Stone Ridge Quarry Project (SSD-10432) (Port Stephens)

I refer to your request for advice on the Major Projects Portal on 16 June 2023, in which Resource Assessment Division of the Department of Planning and Environment (the Department) invited Biodiversity and Conservation Division (BCD) to provide advice in relation to the proposed hard rock quarry, known as Stone Ridge Quarry (the Project), located within Wallaroo State Forest at Balickera, NSW.

BCD's recommendations

BCD's detailed comments

**FIGURE 3.1**  
**Stage 1 Conceptual Water Management System Plan**

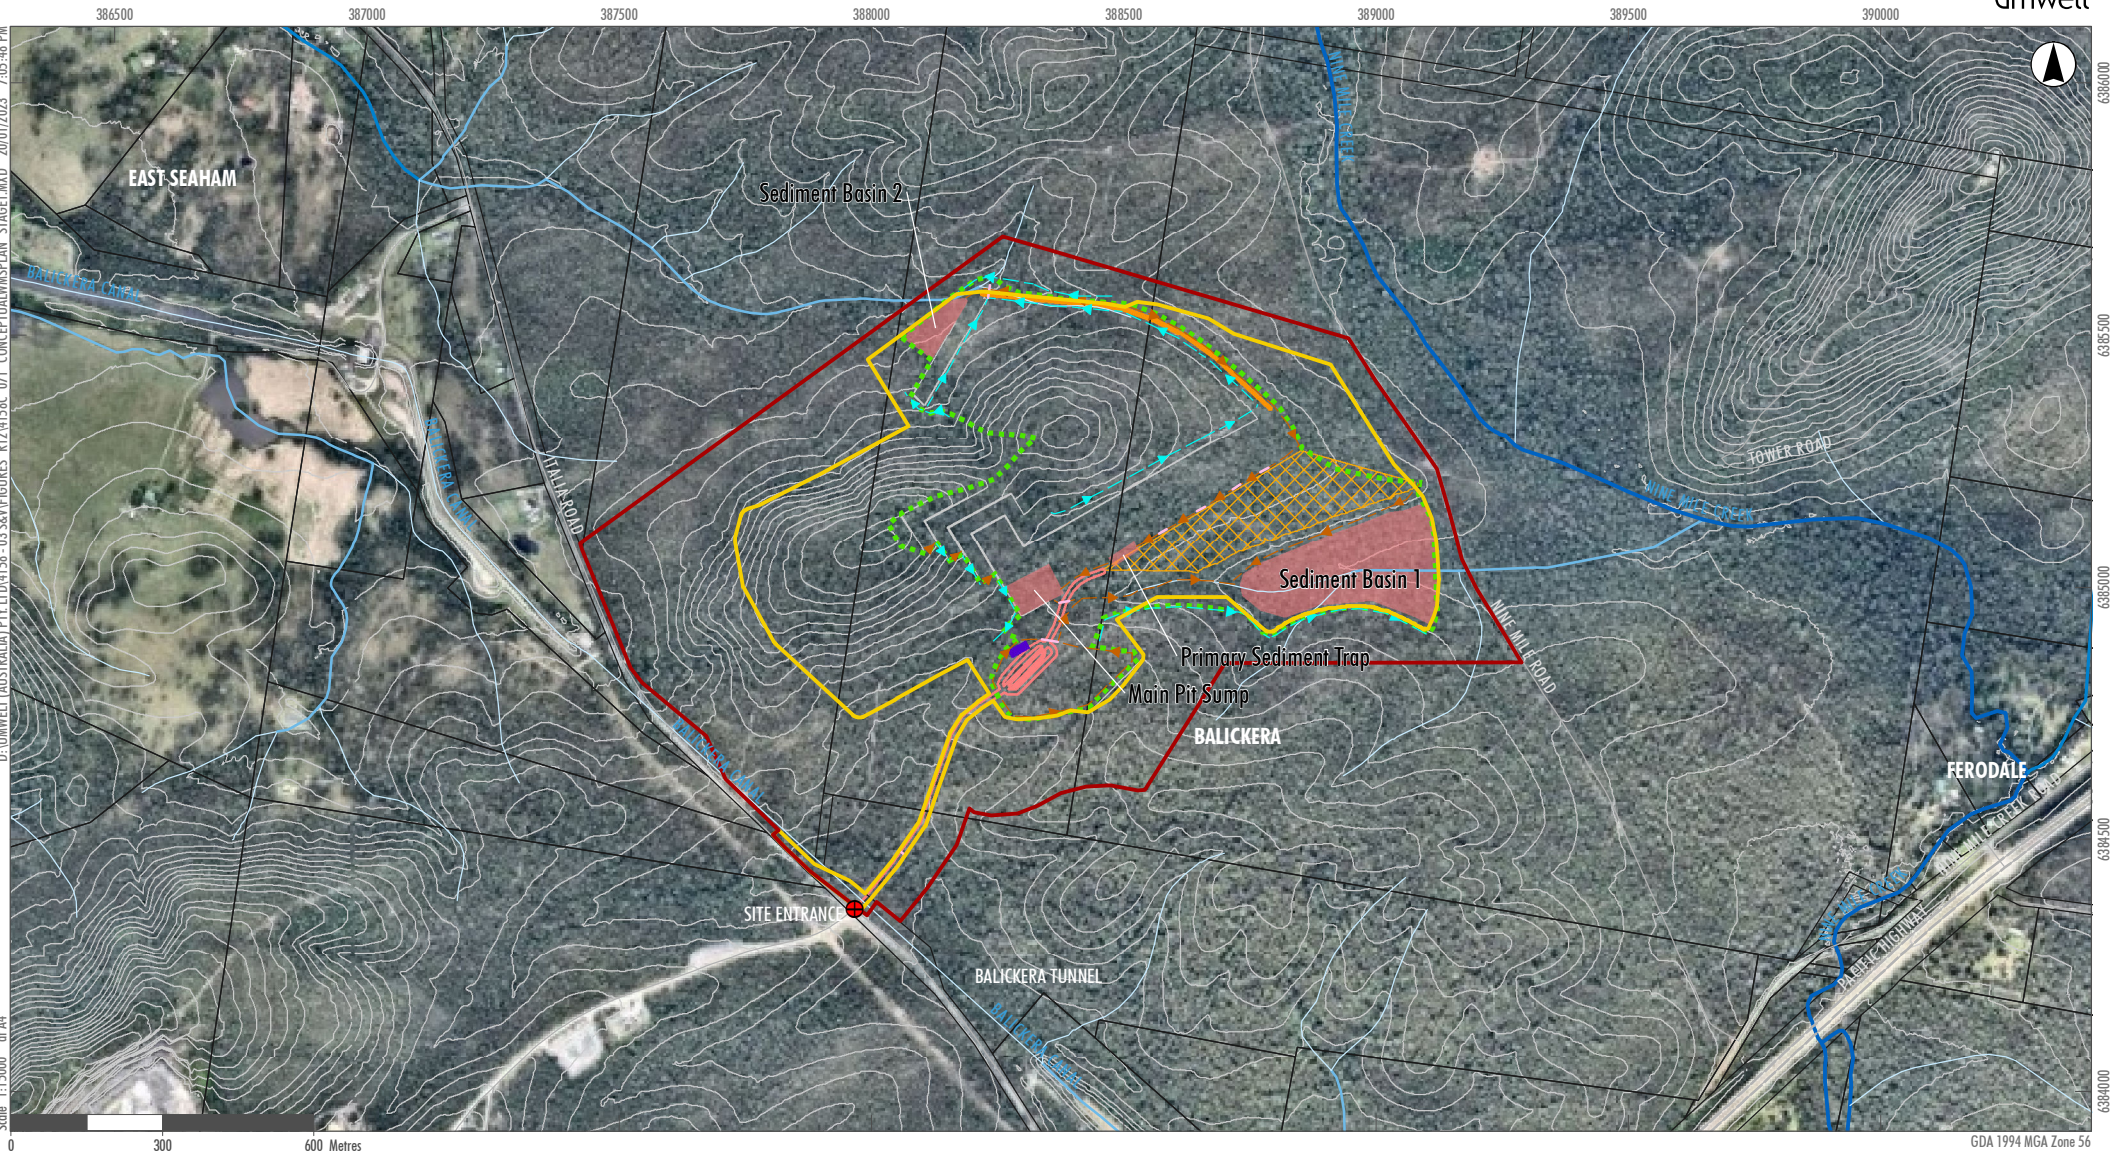
The proposed plans suggest that sedimentation basin SW1 is to be constructed in a 2nd order stream. This is not in line with best practice, which is to locate pollution controls offline, away from waterways. This is to prevent pollutants from being remobilized by high flows and to protect property, people, and the environment in the event of a failure.

The sediment basin SW1 should not be located within a waterway.
